**Addendum No. 1**

RE: Contract ID C203095

**Wake County**

7 Sections of Secondary Roads

TYPICAL SECTION 1

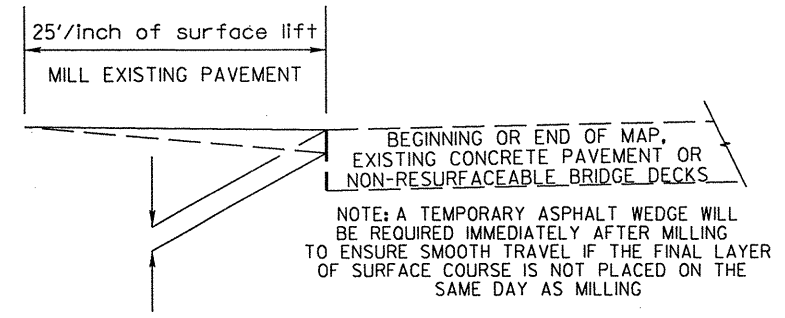
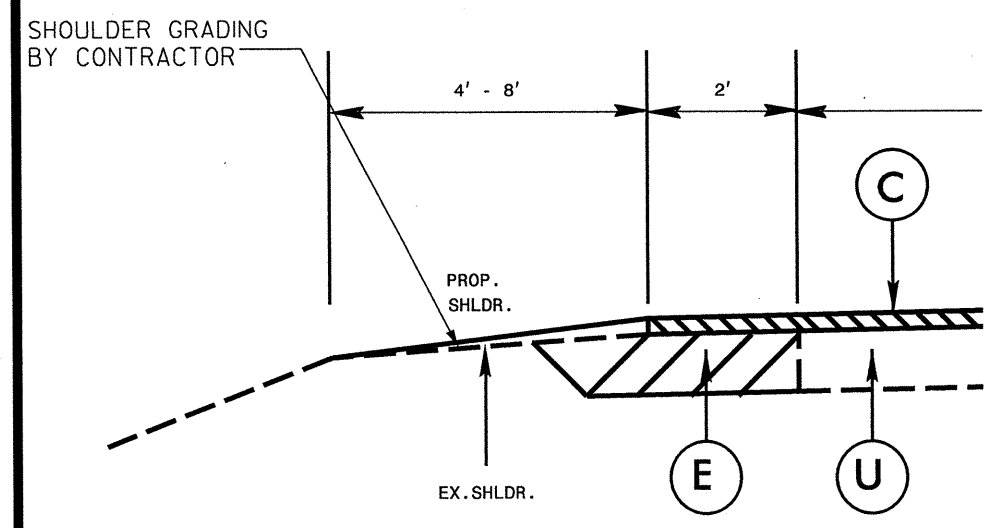
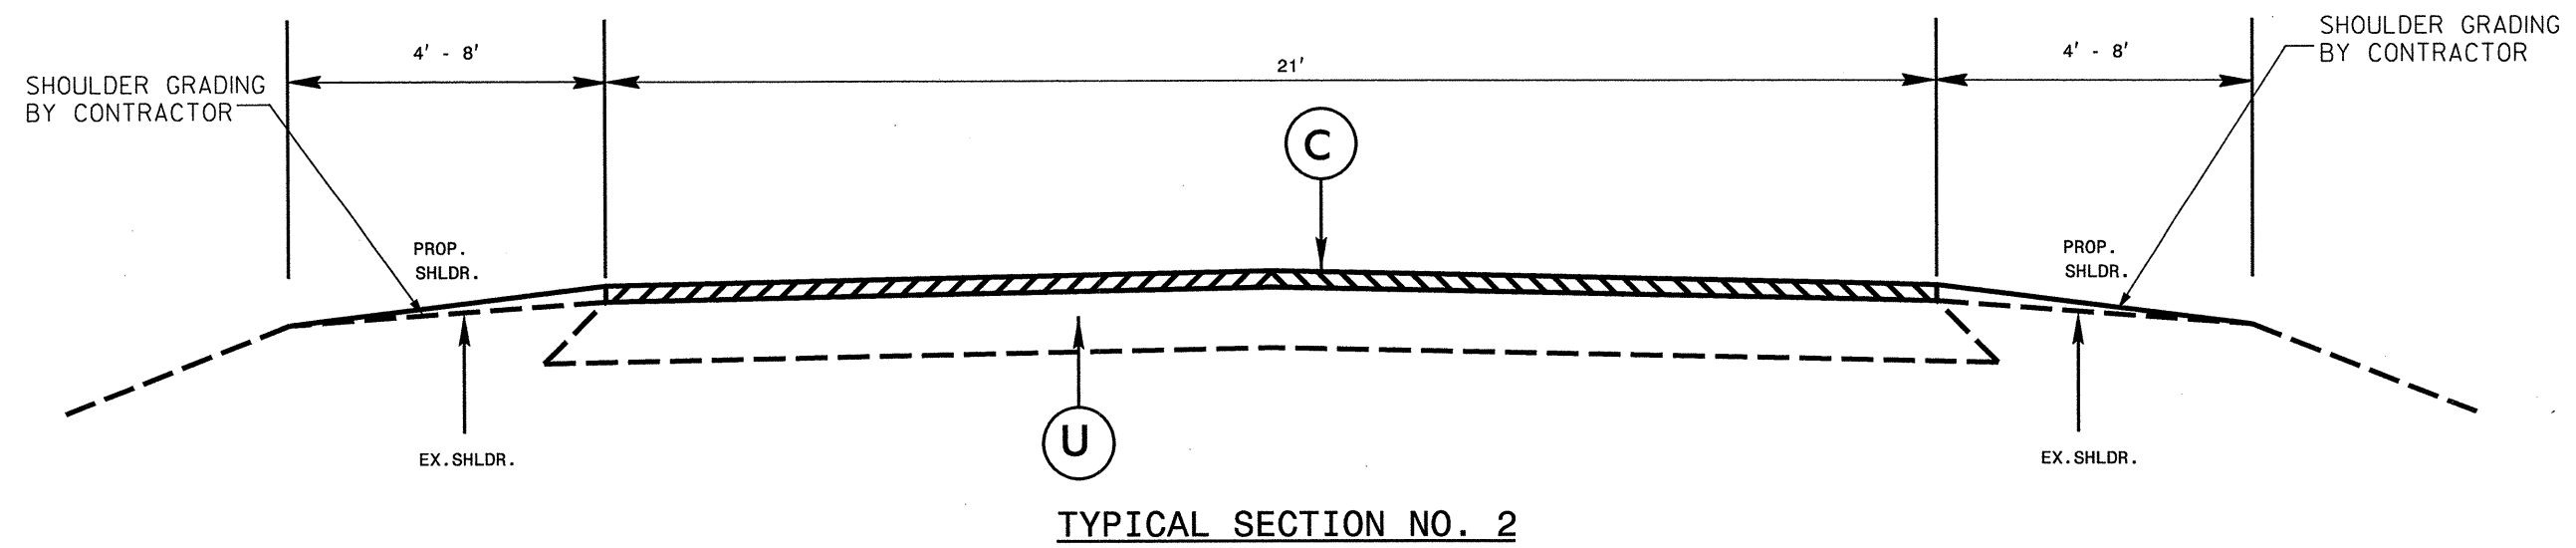
On Sheet Nos. 6, 7 and 8 the Pavement Schedule has been revised to include the cement rate for V1. Please void Sheet Nos. 6, 7 and 8 in your plans and staple the revised Sheet Nos. 6, 7 and 8 thereto.
